# **Awel y Môr Offshore Wind Farm Examination Review of SLVIA Documents**

**Final report**  
Prepared by LUC  
October 2022

### Awel y Môr Offshore Wind Farm Examination Review of SLVIA Documents

**Volume 6, Annex 10.5: SLVIA
Visualisations - Figure 35
(ViewPoint 8 - Beaumaris - Wales
Coast Path)**

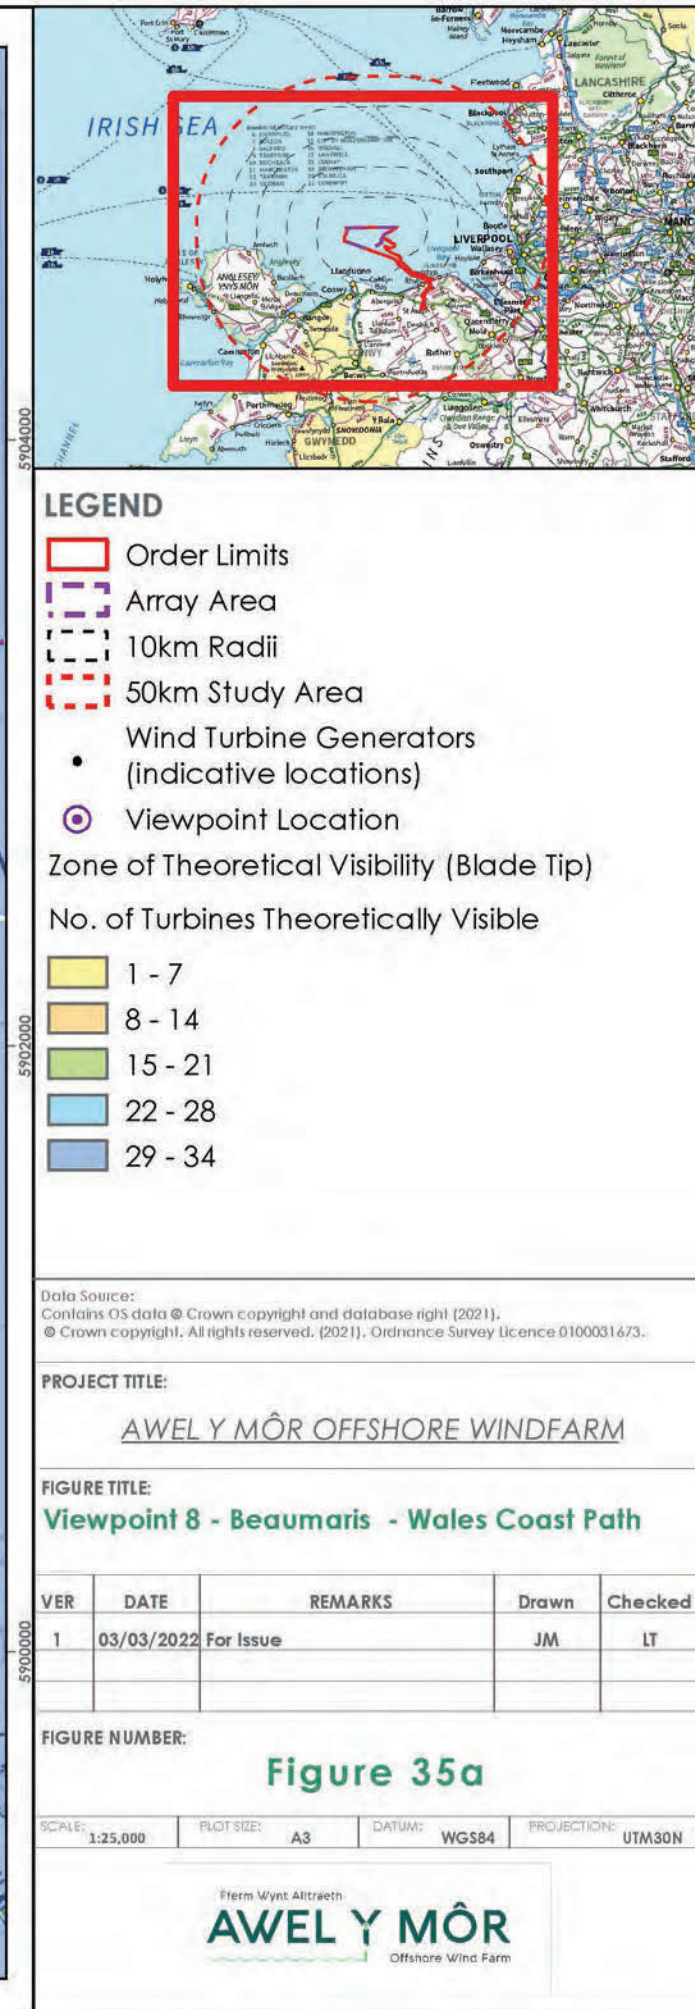
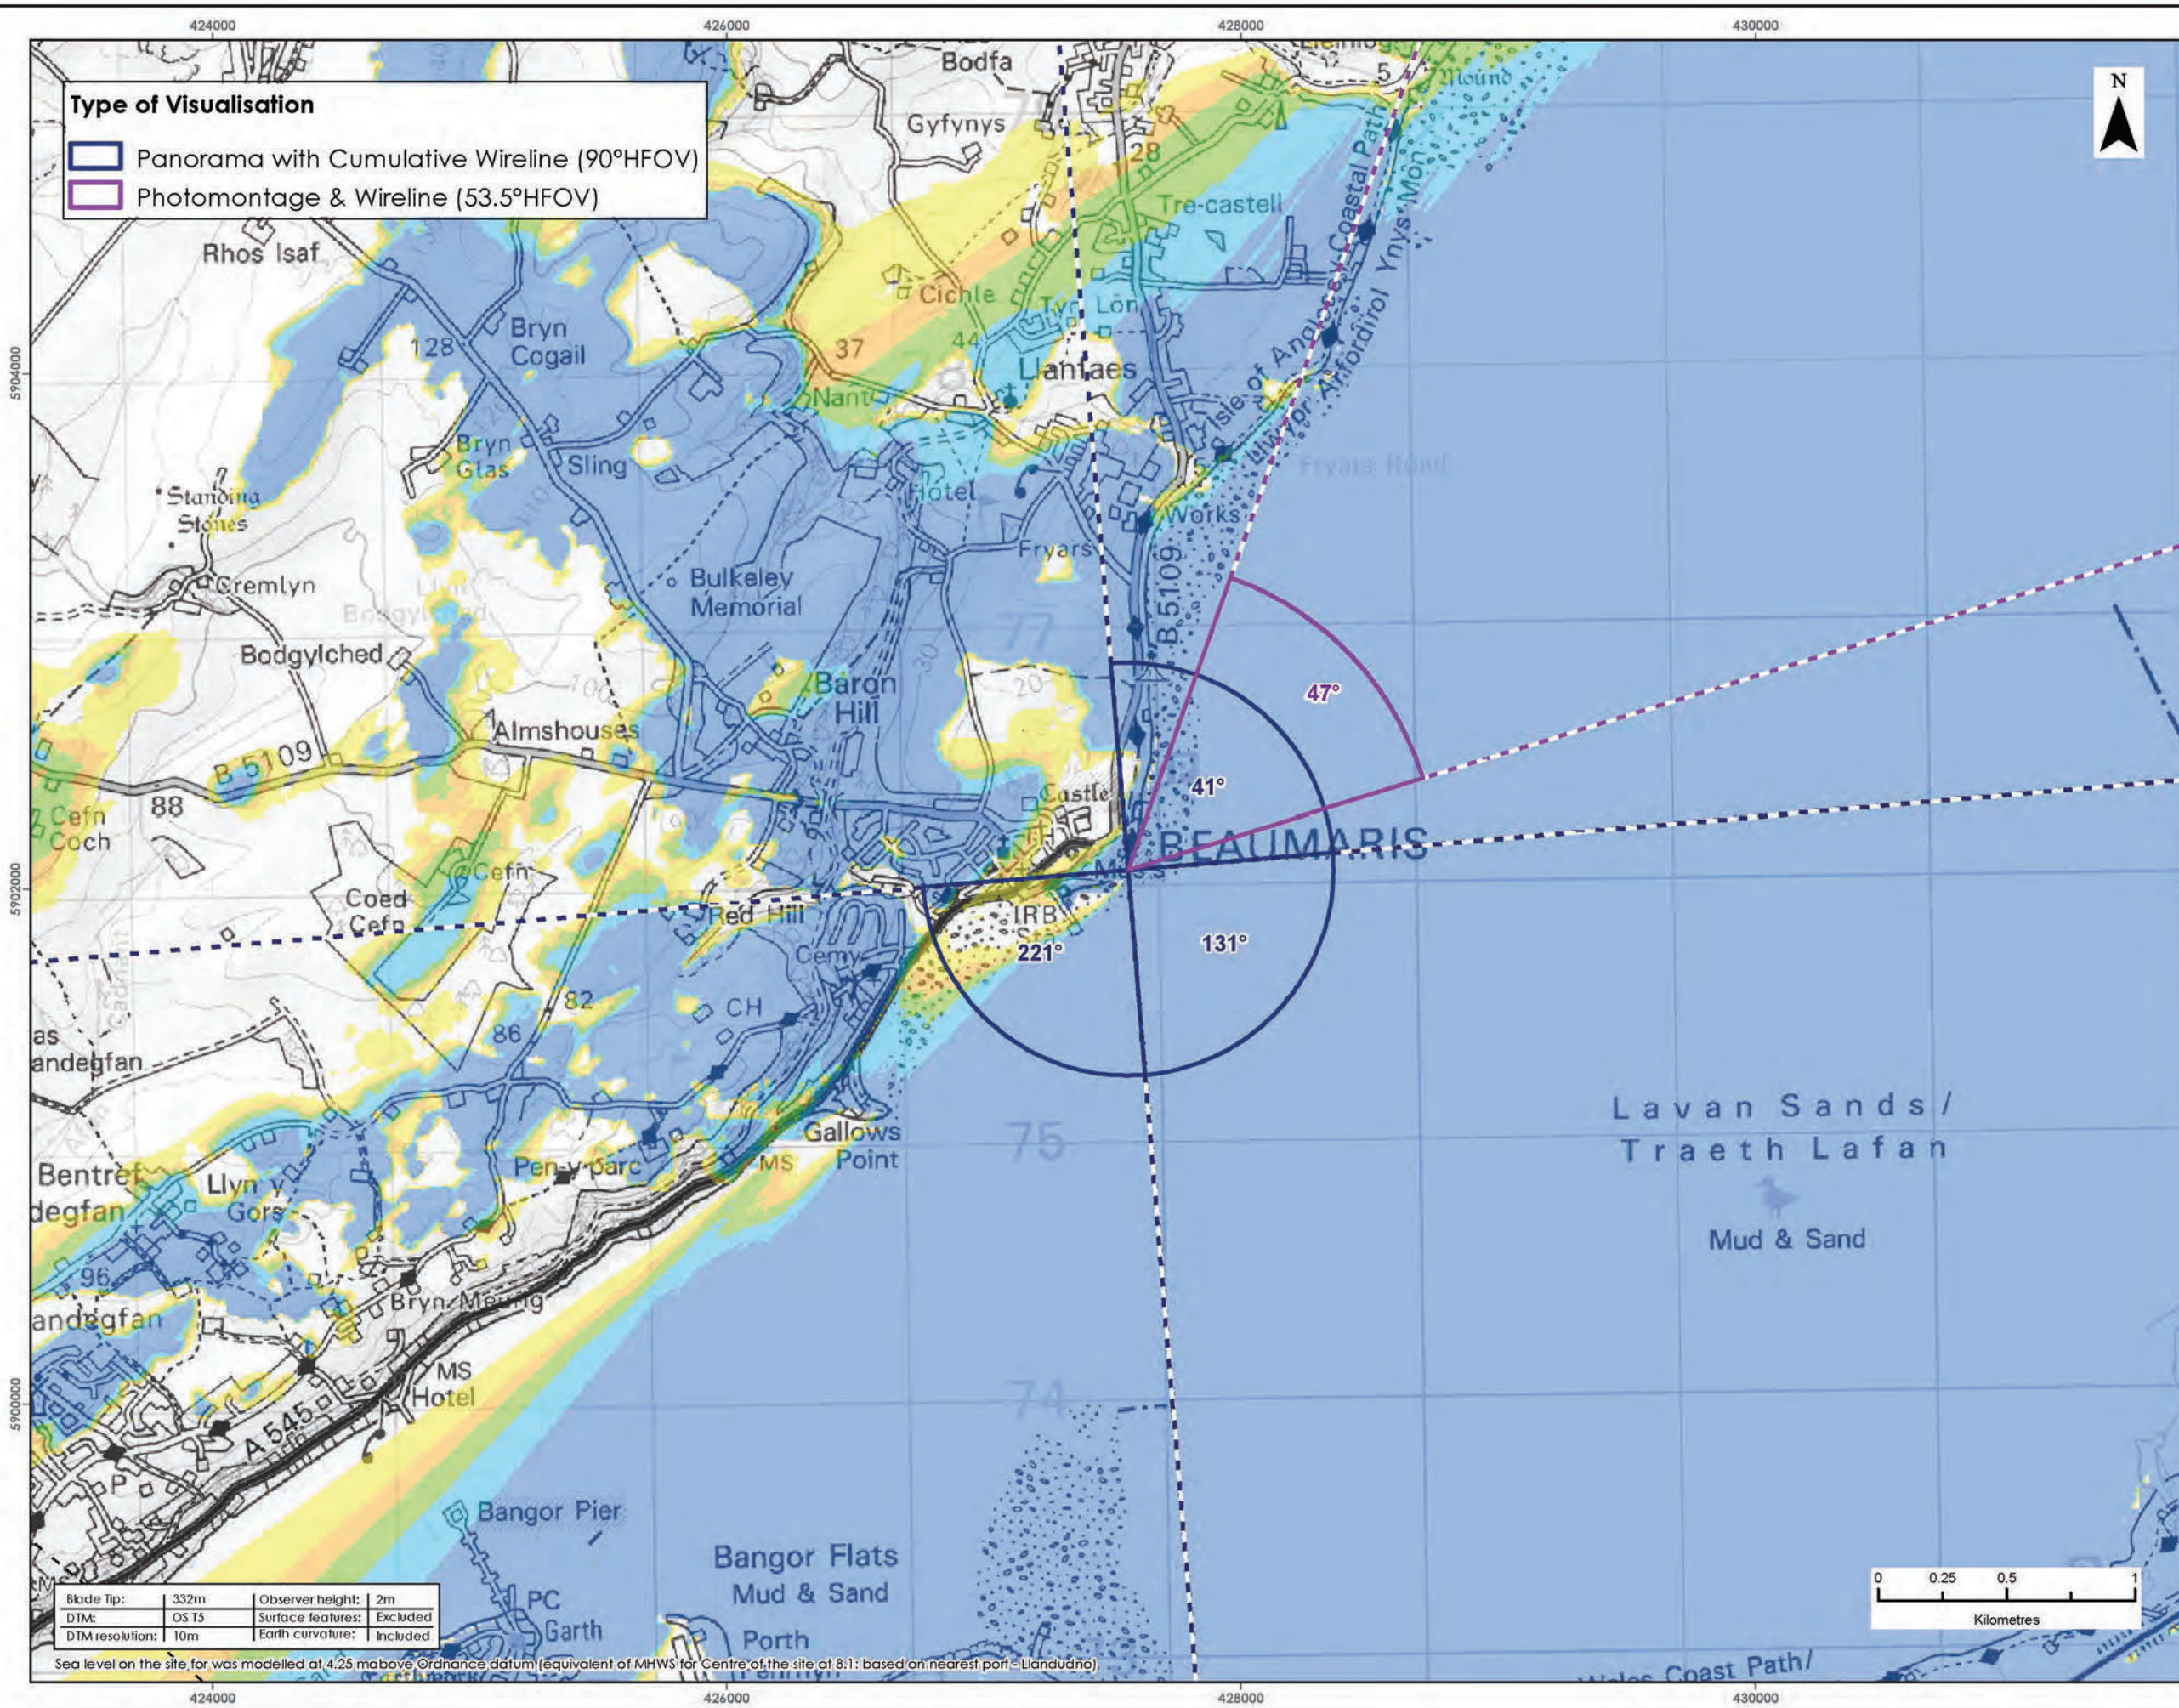
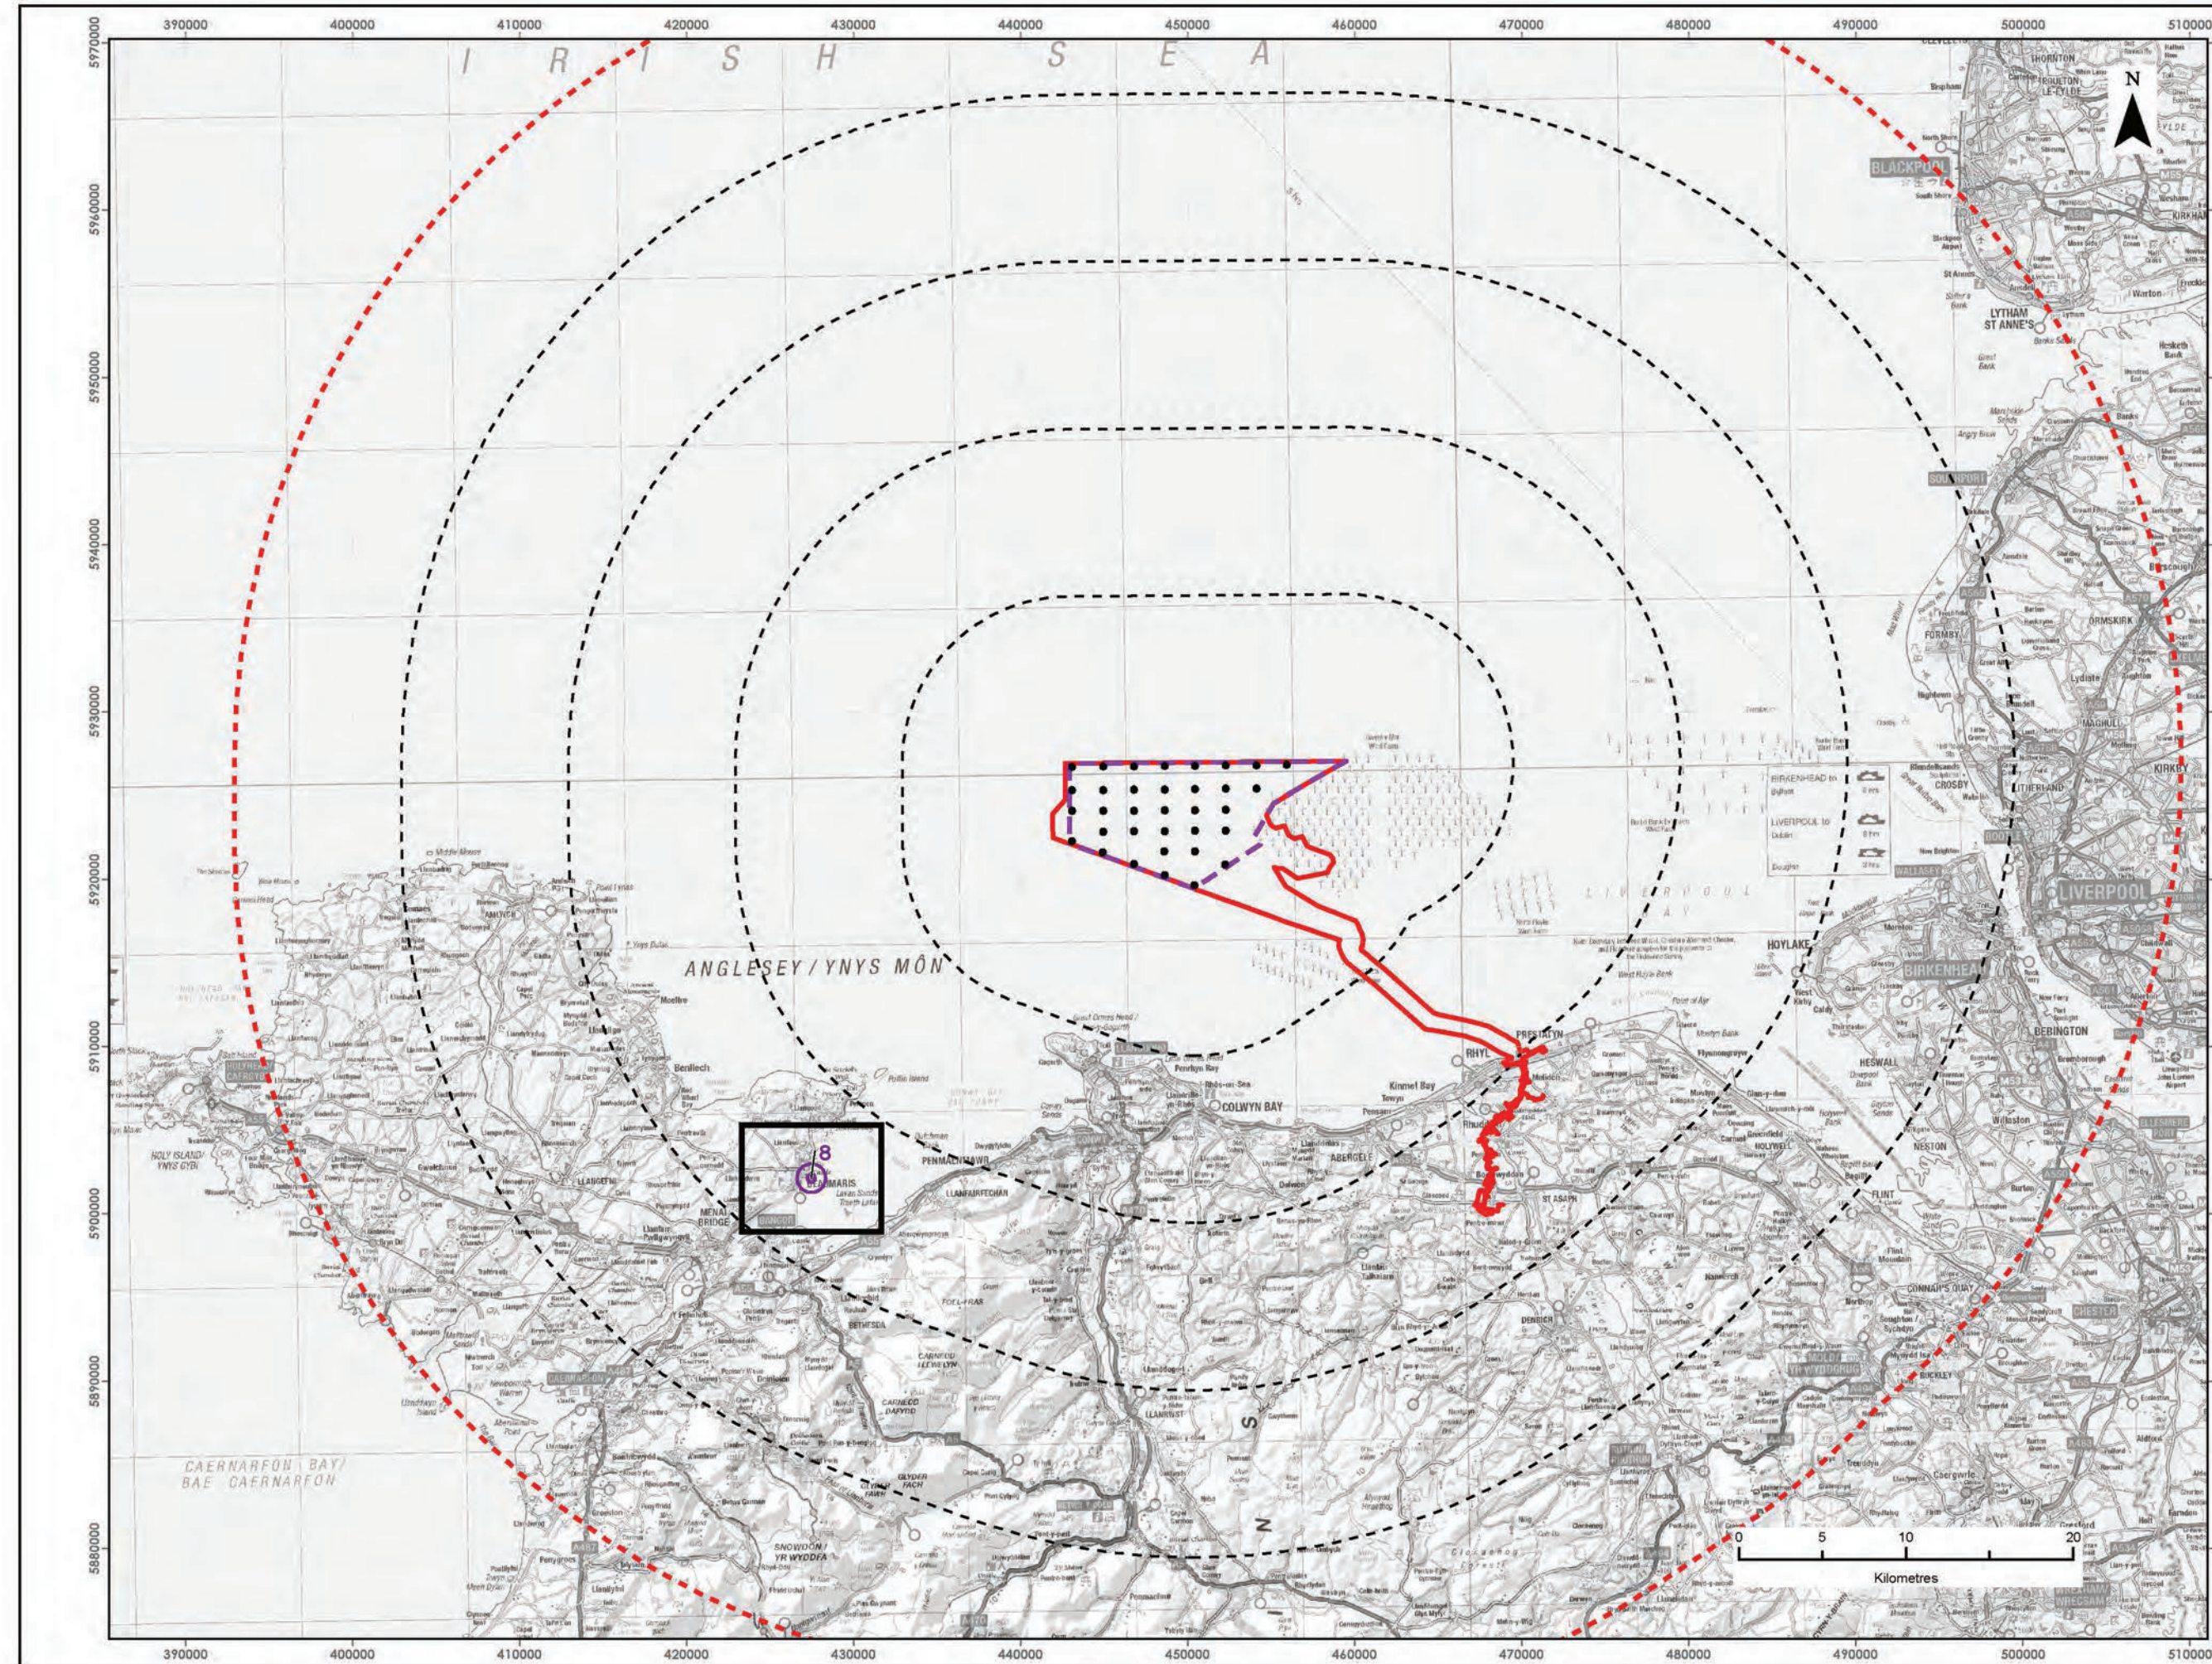
**3.9** There are 13 assessment viewpoints on Anglesey, and the SLVIA finds significant effects at eight of these locations. This is the same result as in the PEIR. All the identified significant effects are 'moderate', with the exception of VP7 Penmon Point and VP8 Beaumaris, which are 'major-moderate'. These findings are agreed.
